Application number: 2026/92294	
What is the application for?:	Variation of condition 2 (plans and specifications) on previous permission 2025/
Address of the site or building:	36, Scholes Moor Road, Scholes, Holmfirth, HD9 1SJ
Postcode:	HD9 1SJ

Type of comment: An objection	
Do you wish your comments to be published on the website anonymously?	Yes

South West Elevation (side)

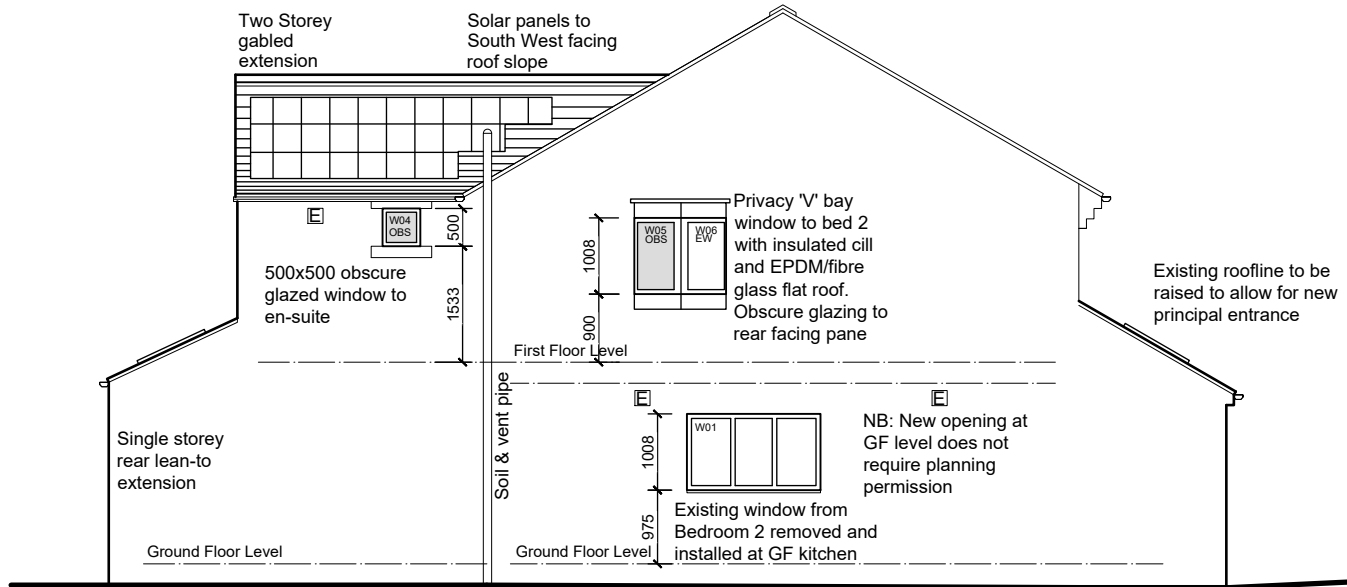
We are writing to formally object to the proposed insertion of a first-floor side-facing window at the neighbouring property.

We are particularly concerned about the impact that the proposed window would have on the privacy and residential amenity of our property. The window is proposed at approximately 1600mm above the internal floor level, which is approximately eye level for an average adult. However, this stated height does not, in itself, address the potential privacy impact because of the difference in levels between the two properties. The neighbouring property is situated lower than our property. Consequently, despite the window being described as side-facing and positioned at 1600mm above internal floor level, its actual relationship to our property would provide a direct and intrusive line of sight towards and into our bedroom.

The proposal should therefore be assessed having regard to the actual difference in ground and floor levels between the two properties and the resulting lines of sight, rather than simply considering the nominal height of the window. The difference in levels materially alters the relationship between the proposed window and our property and creates a new and direct overlooking relationship that does not currently exist. It should also be noted that the amended proposal does not specify that obscured glass would be used, despite this being a stipulation when the existing first-floor window was previously agreed. We therefore do not consider that the proposed 1600mm window height adequately addresses the potential loss of privacy.

We are also concerned about the existing privacy relationship created by the recently inserted ground-floor window. The application states that this window has already been reduced to two panes in consideration of the privacy of both properties. While the window is offset from our property, it could have been positioned further to the side to provide greater separation and reduce the potential for direct overlooking.

The newly inserted two-pane window nevertheless compromises our privacy, as it provides a clear view into our dining room. At the same time, we have a clear view into the neighbouring property's newly created kitchen area. The current positioning therefore creates overlooking in both directions and does not, in our view, adequately address the privacy concerns between the two properties.

The proposed first-floor window would create a further and more significant overlooking relationship, particularly given the substantial difference in levels between the properties. We therefore respectfully ask that the Planning Office gives careful consideration to the actual relationship between the two properties, including their respective ground and floor levels, the resulting lines of sight, and the consequent impact on privacy and residential amenity.
